# City of Albuquerque

## DRAINAGE AND TRANSPORTATION INFORMATION SHEET (REV 09/2015)

**Re: 2100 Osuna NE**  
**Traffic Circulation Layout**  
Engineer's Stamp **02-08-18** (E16-D001)

Based upon the information provided in your submittal received 02-12-18, the above referenced plan cannot be approved for Building Permit until the following comments are addressed:

ENGINEER'S SEAL	2100 OSUNA	DRAWN BY WCWJ
		DATE 1-26-18
		21724-LAYOUT-3-24-17
		SHEET #
		JOB # 21724
11/15/18 DAVID SOULE P.E. #14522	 <i>Rio Grande Engineering</i> 1606 CENTRAL AVENUE SE SUITE 201 ALBUQUERQUE, NM 87106 (505) 872-0999

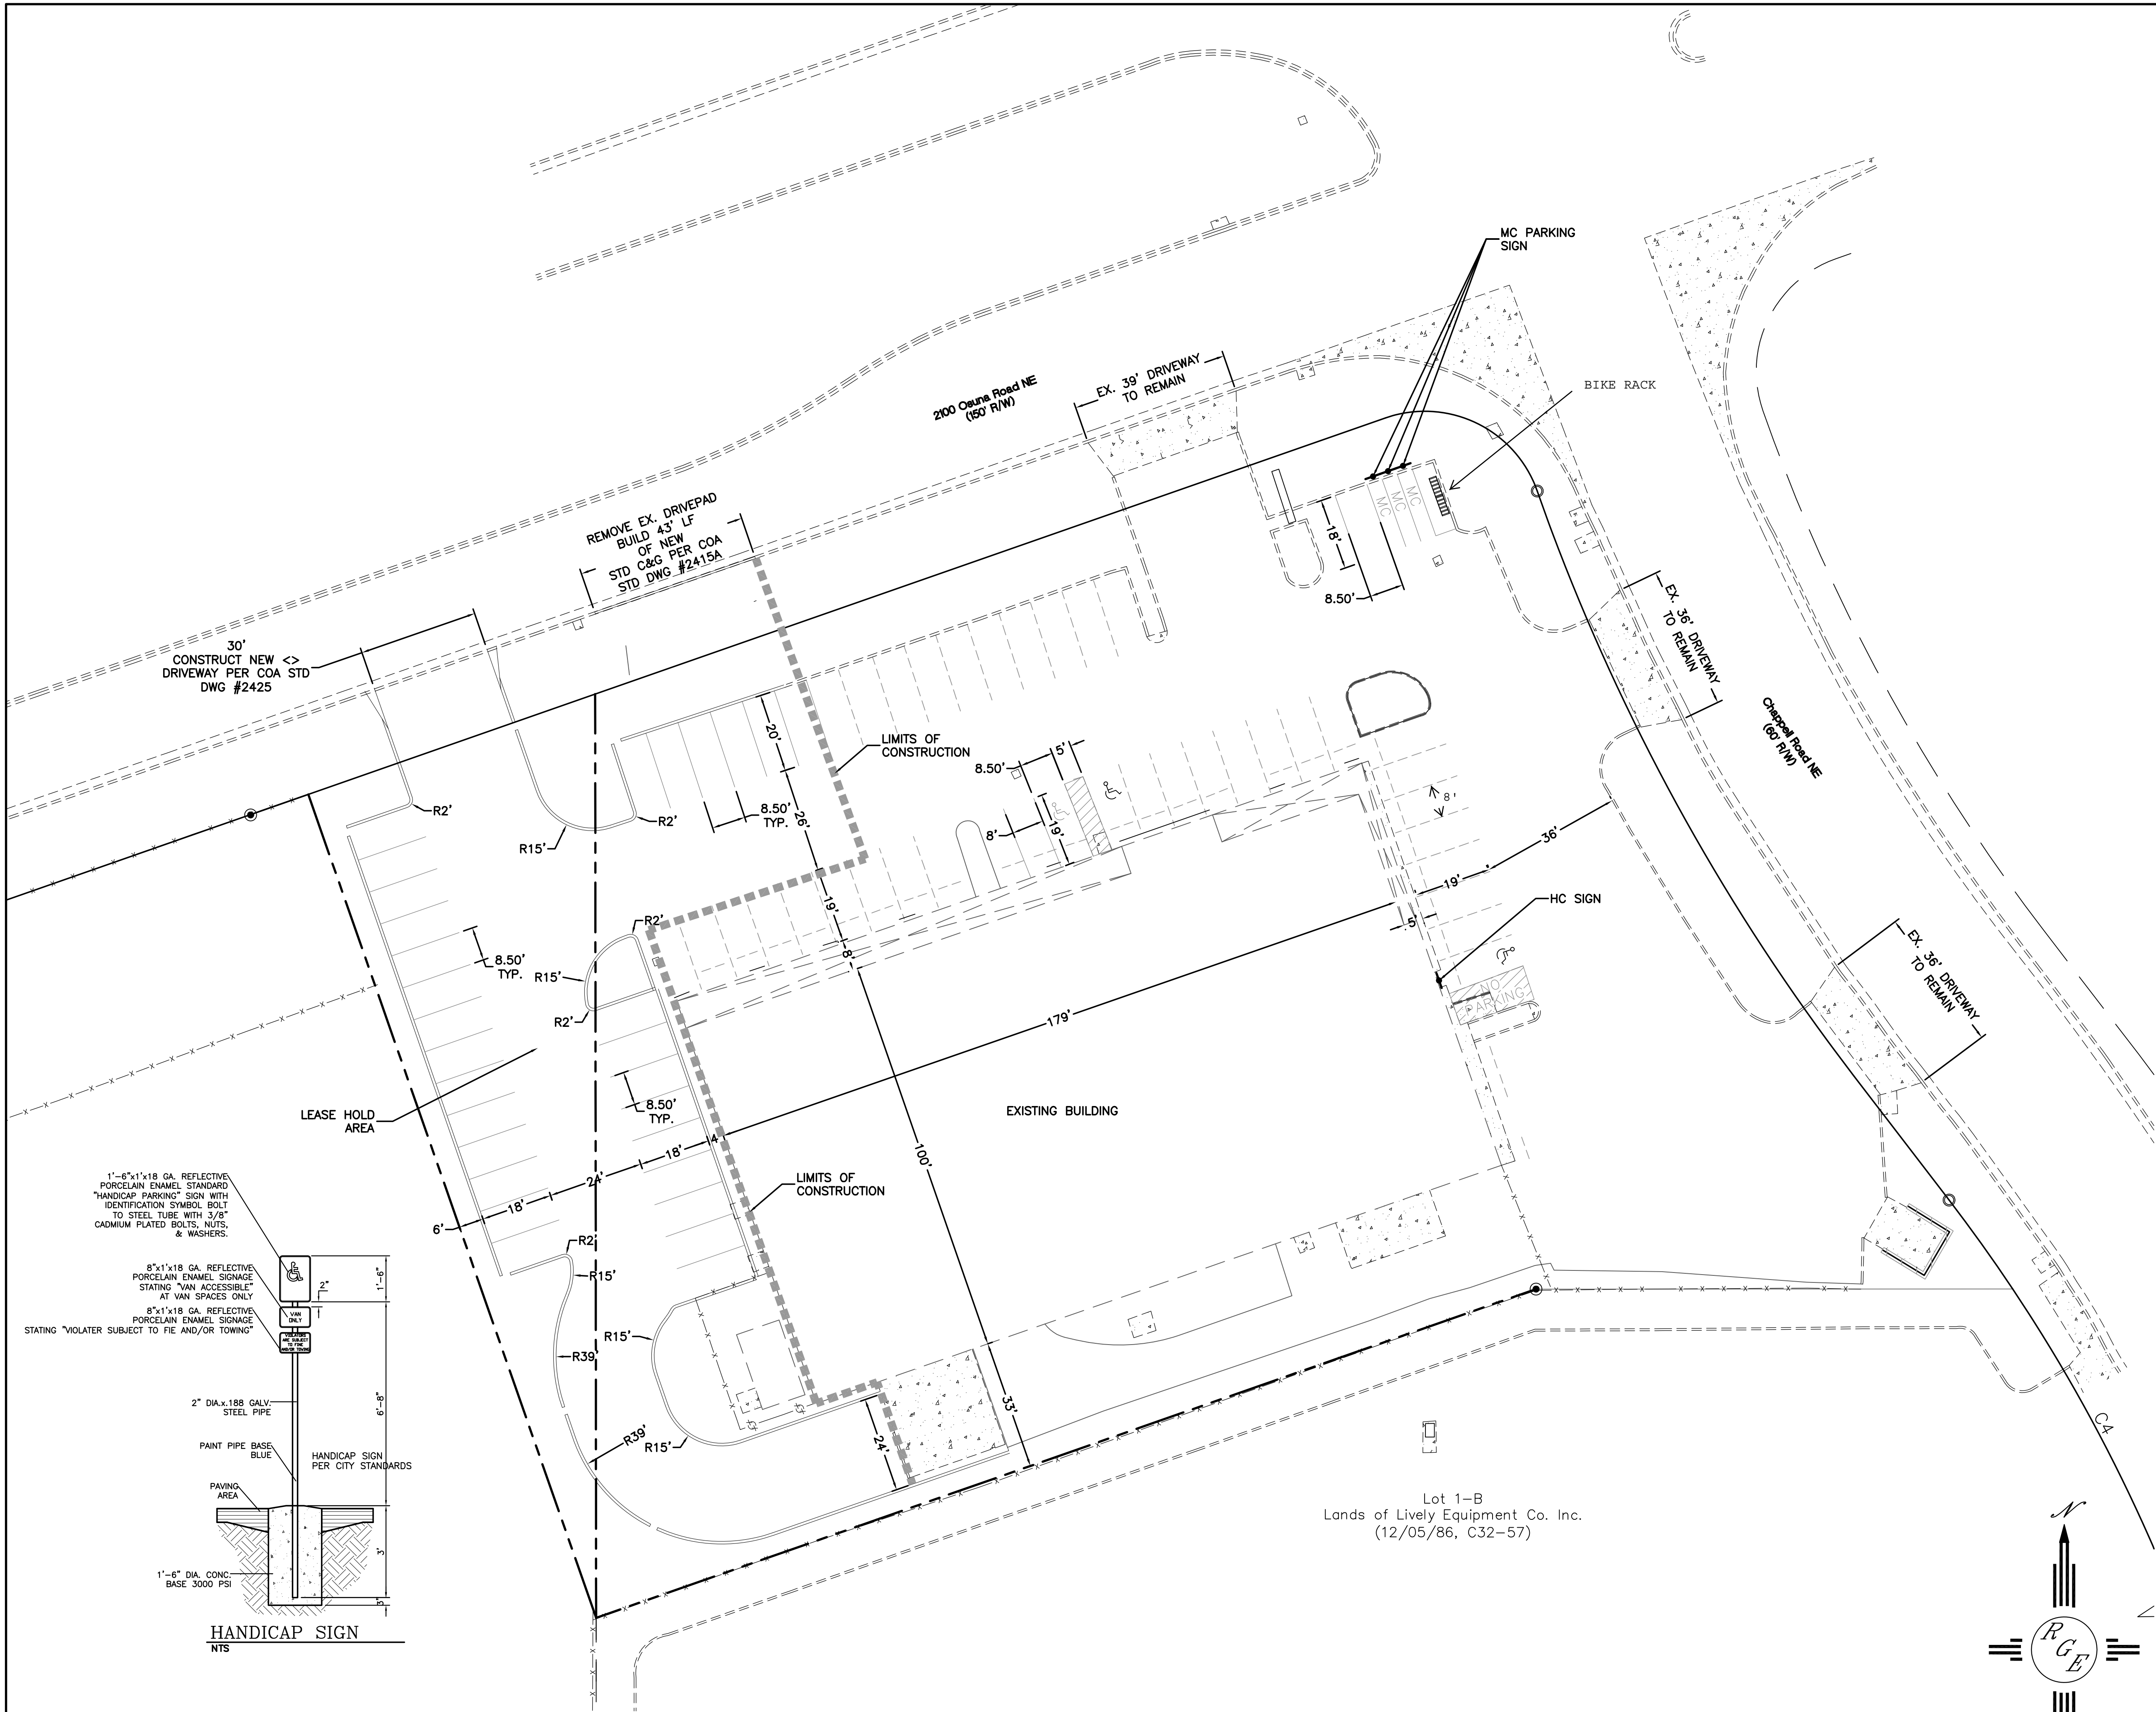
1. Cross access easements/agreements may be needed. Shared parking agreement may be required to use parking spaces for credit to development.
2. The neighbor property 1500 Osuna is zoned SU-1 and may need an Administrative Amendment or DRB action.
3. Please list the width and length for all existing and proposed parking spaces. Some dimensions are not shown. Existing ADA parking spaces will need to be updated to current standards.
4. Motorcycle parking and bicycle rack locations must be added per zoning code. Motorcycle parking spaces shall be designated by its own conspicuously posted upright sign, either free-standing or wall mounted per the zoning code.
5. Please include a copy of your shared access agreement with the adjacent property owner.
